Application by Morecambe Offshore Wind Limited for Morecambe Offshore Windfarm Generation Assets

The Examining Authority's additional written questions and requests for information (ExQ3)

Issued on 25 March 2025

4 Liverpool Bay SPA with 1.5nm CPP1 WTG and OSP Aviation Buffer and 1.5nm Calder WTG and OSP Buffer

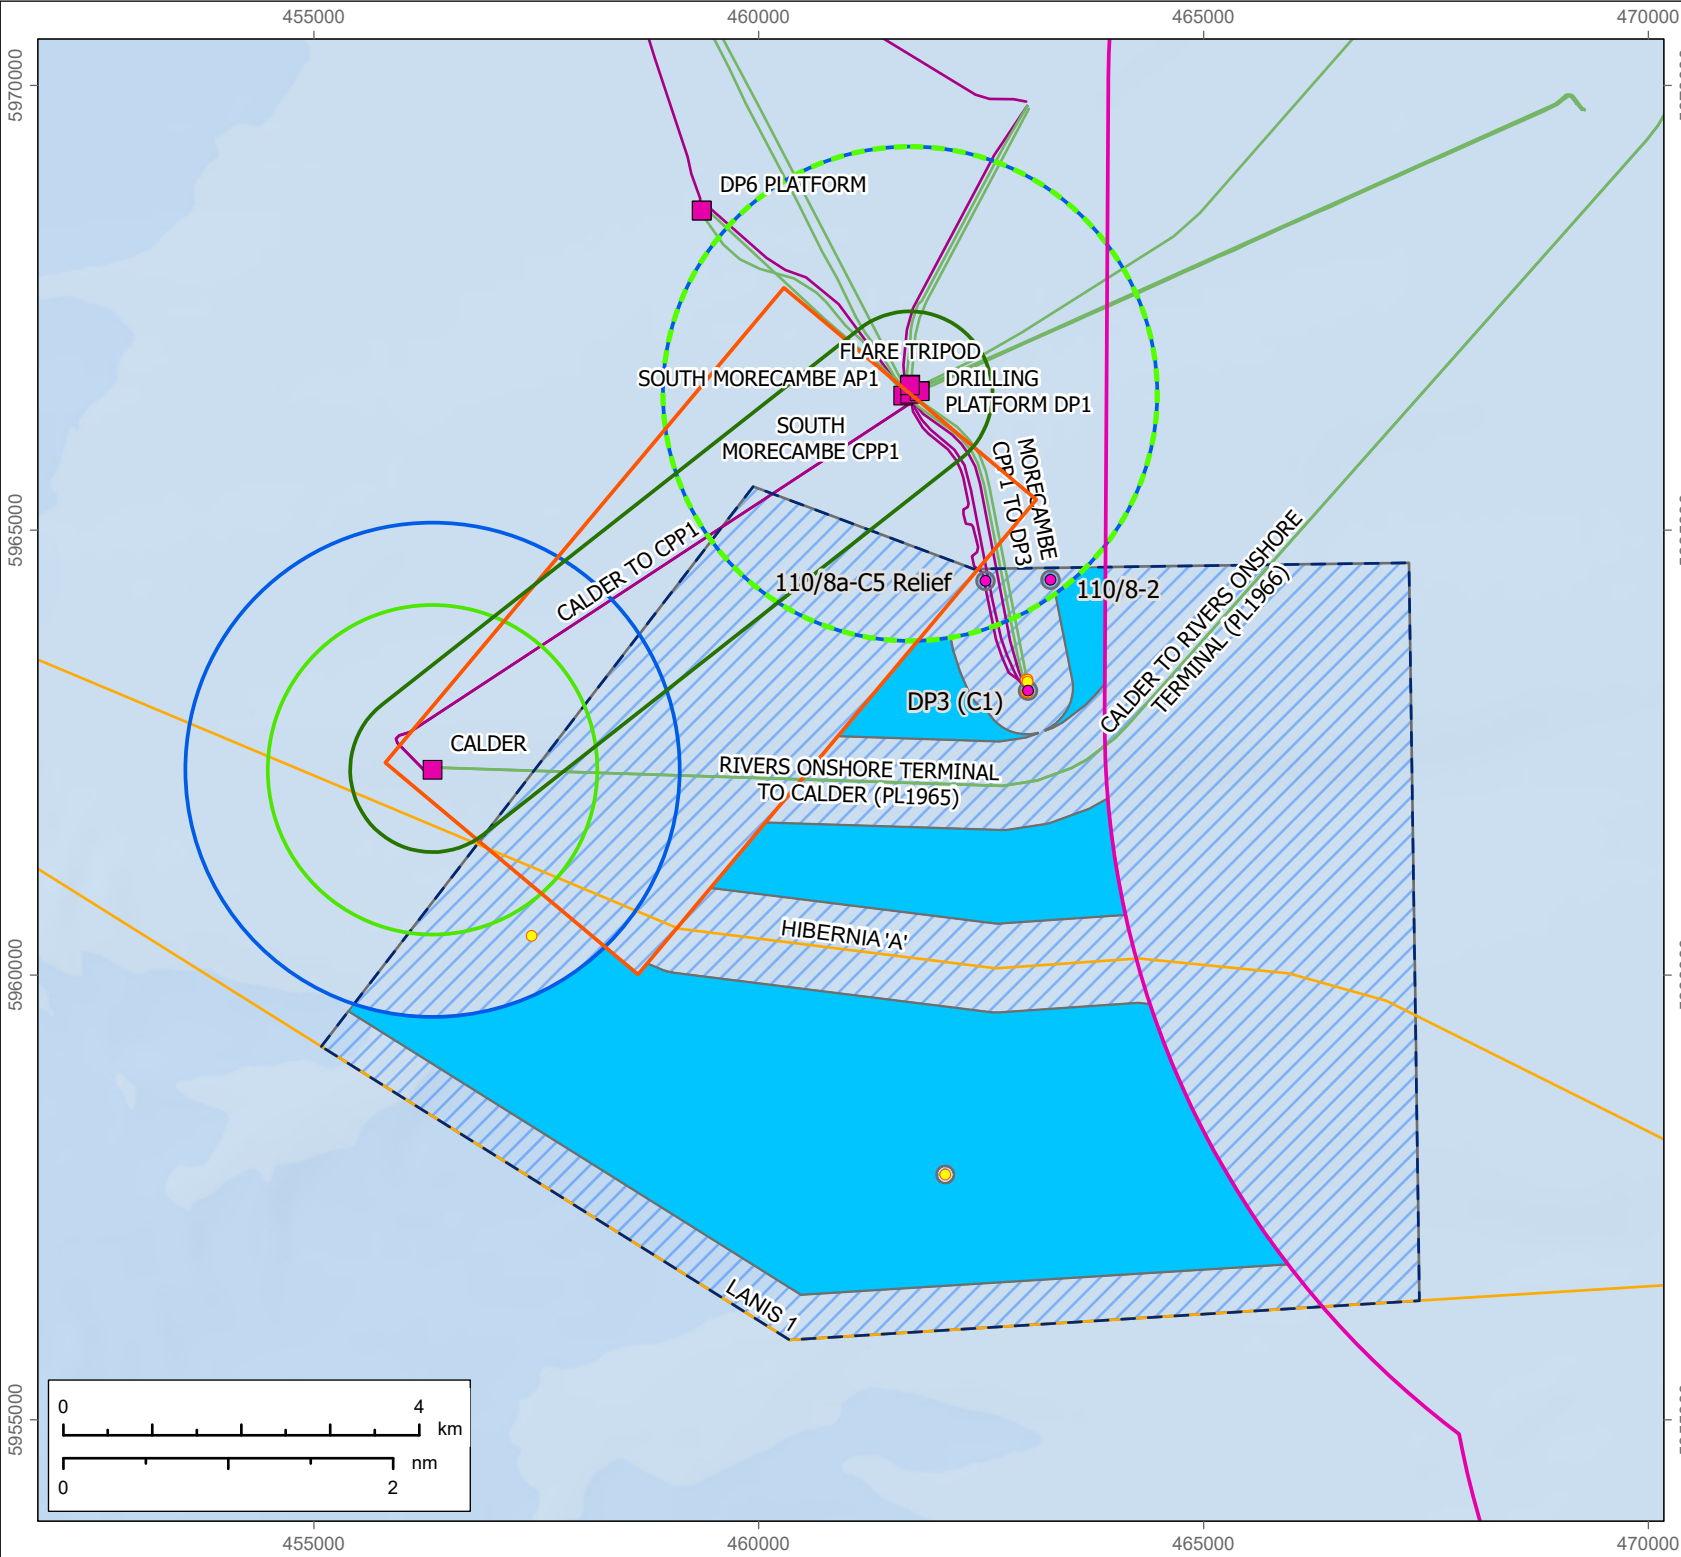
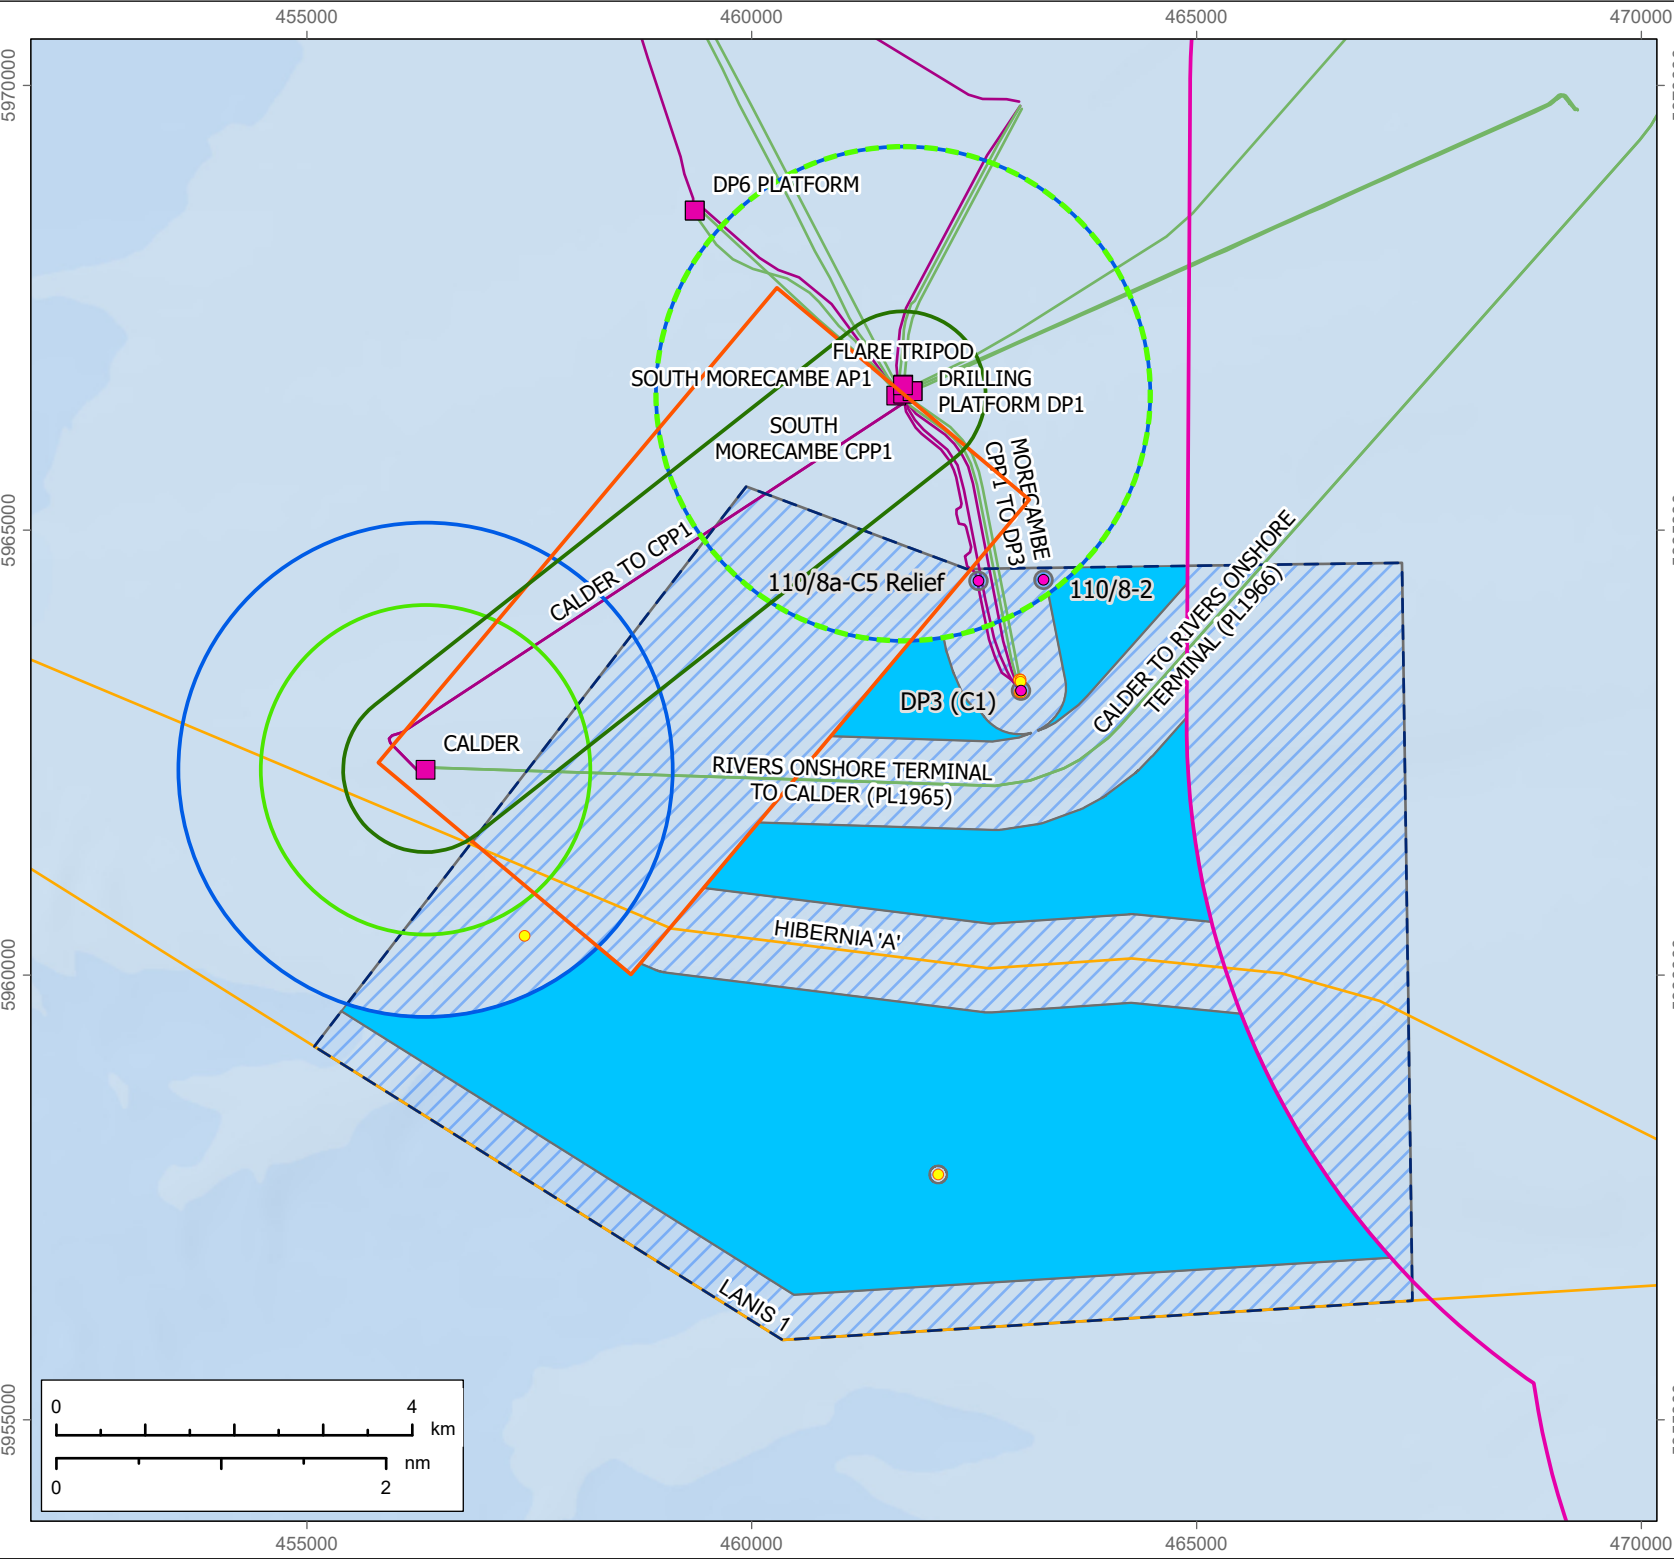
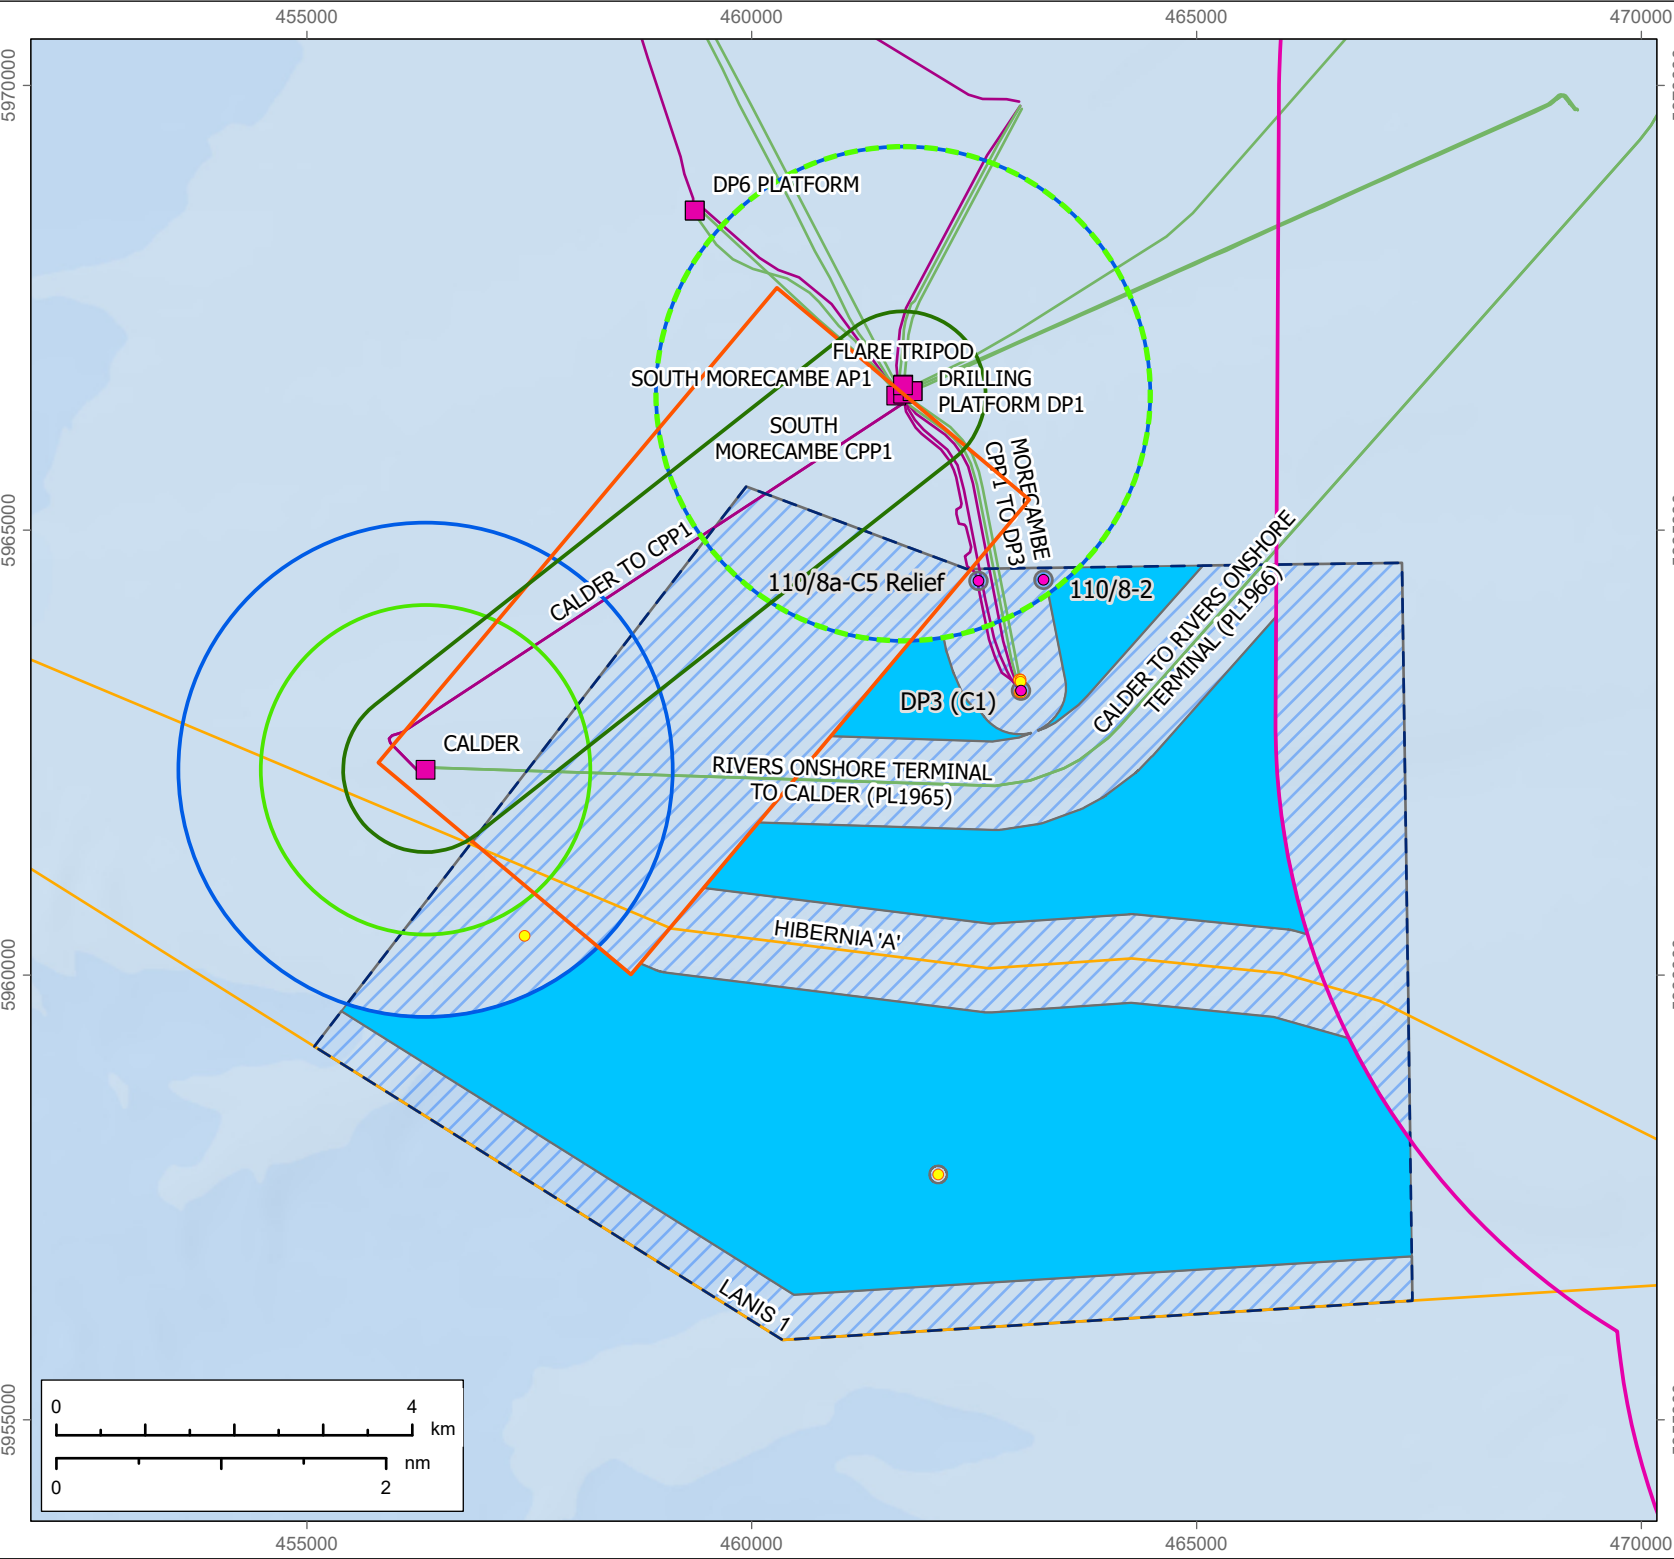
ExQ3	Question to:	Question:										
3GEN3.	The applicant	<p>Liverpool Bay SPA and Oil and Gas Platform Buffers</p> <p>Whilst the ExA notes the caveats stated in the applicant’s response to ExQ2HRA6 at D5 [REP5-070], to further demonstrate and support the applicant’s position:</p> <p>a) please can the applicant provide individual plans to demonstrate the impact that each of the incrementally smaller buffers from the original Liverpool Bay SPA would have on the layout and number of WTGs that could be accommodated within the site (i.e. 10km, 9km, 8km, 7km and so no buffer associated with the SPA affects the site) - with all other existing buffers/ corridors as shown on [REP5-007] unchanged.</p> <p>b) in Spirit Energy’s response to ExQ2CAR5 at D5 [REP5-090] it advises a buffer distance of 1.9nm is the minimum acceptable requirement for safe landing and take-off in daytime VMC and for night VMC this distance would be 2.4nm. In light of this could the applicant provide plans for each alternative SPA buffer scenario in (a) plus each of the increased buffer scenarios from the Calder and CCP1 platforms as set out in the following table.</p>

<p>c) any additional comments or further information the applicant wishes to provide on the implications of each of the above scenarios (noting the applicant’s previous response [REP5-070], EXQ2HRA3 and 2HRA6].</p> <p>The ExA is seeking a complete set of alternative scenarios shown on plans, so that, whatever the SoS may determine, if they felt it was appropriate they could include the relevant plan within any final DCO without having to revert to the applicant for that plan. Each should therefore have a different drawing number.</p>	<u>CPP1 WTG and OSP Aviation Buffer</u>	<u>Calder WTG and OSP Buffer</u>	1.9nm	1.9nm	2.4nm	1.9nm	1.9nm	2.4nm	2.4nm	2.4nm
<u>CPP1 WTG and OSP Aviation Buffer</u>	<u>Calder WTG and OSP Buffer</u>											
1.9nm	1.9nm											
2.4nm	1.9nm											
1.9nm	2.4nm											
2.4nm	2.4nm											
3GEN4.	The applicant	<p>Design Statement - Cabling</p> <p>Could the applicant please explain why (former) provision DC15 relating to use of the most direct/ efficient cabling route to minimise cutting has been deleted from the post-consent design code in Table 6.1 of the Design Statement [REP5-008] and [REP5-009].</p>
